Application no: H06/0733/00

**Description:** Conversion of part of  
outbuilding to form studio.

**Location:** Pulvertoft Hall  
Gedney Broadgate

**Amendment:** Amendment to layout

Pulvertoft Hall • Gedney Broadgate • Lincs
 proposed conversion of outbuilding to studio
 PLANS & ELEVATIONS AS PROPOSED
 scale 1:100 drawn RAE date MAY 2000 drawing no **814/2**

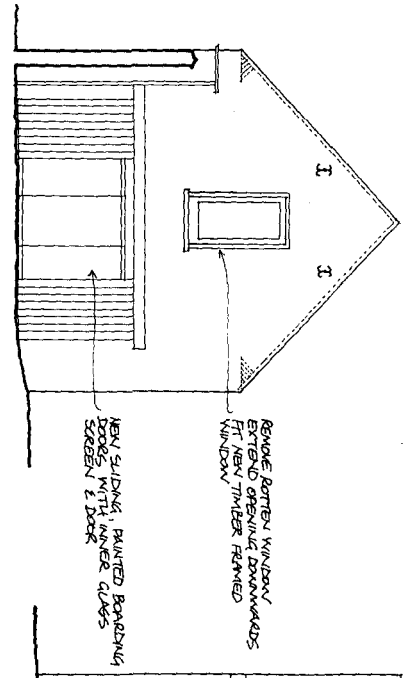
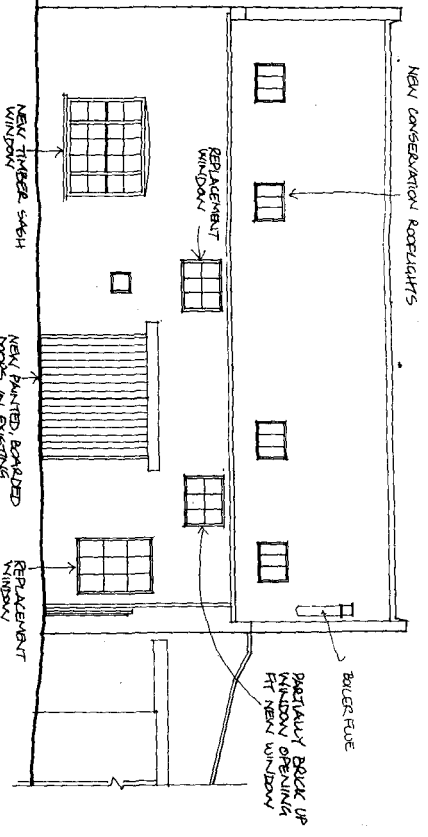
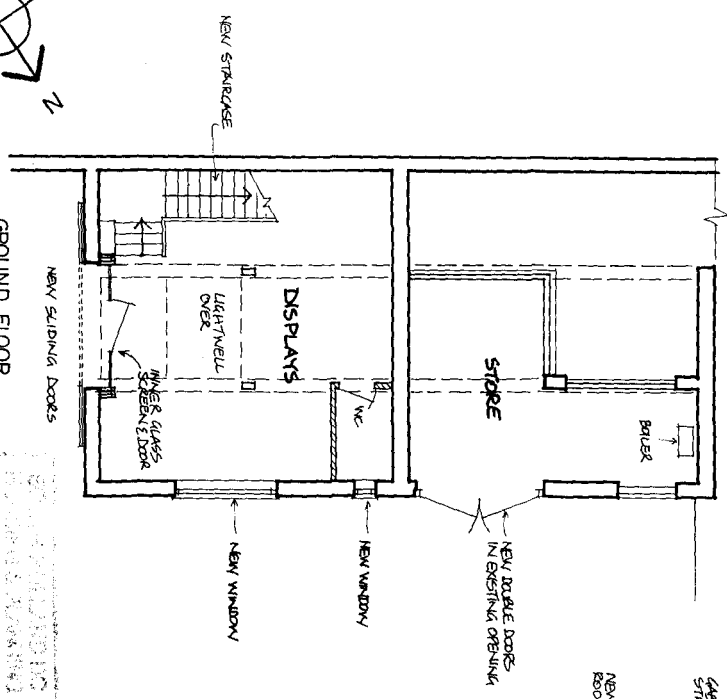
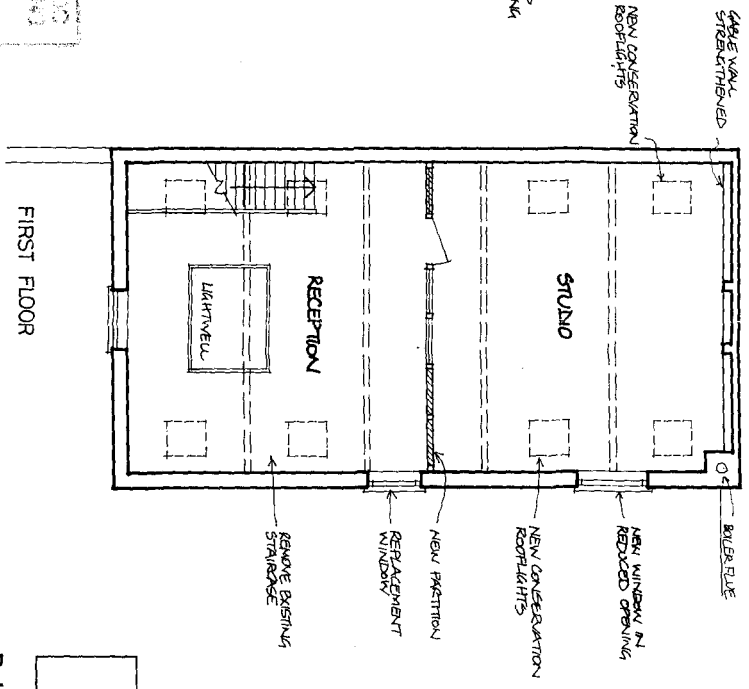
My client has requested a slight amendment to the layout, resulting in the re-positioning of two windows on the side elevation. I enclose one copy of the approved drawing, together with one copy of the working drawing no 814/11C. I have high-lighted the revisions. Would you kindly confirm that this is a non-material alteration to the approved scheme?

The amended details submitted in respect of the above proposal have now been considered and there are no objections to the amendment being implemented to the extent described above.
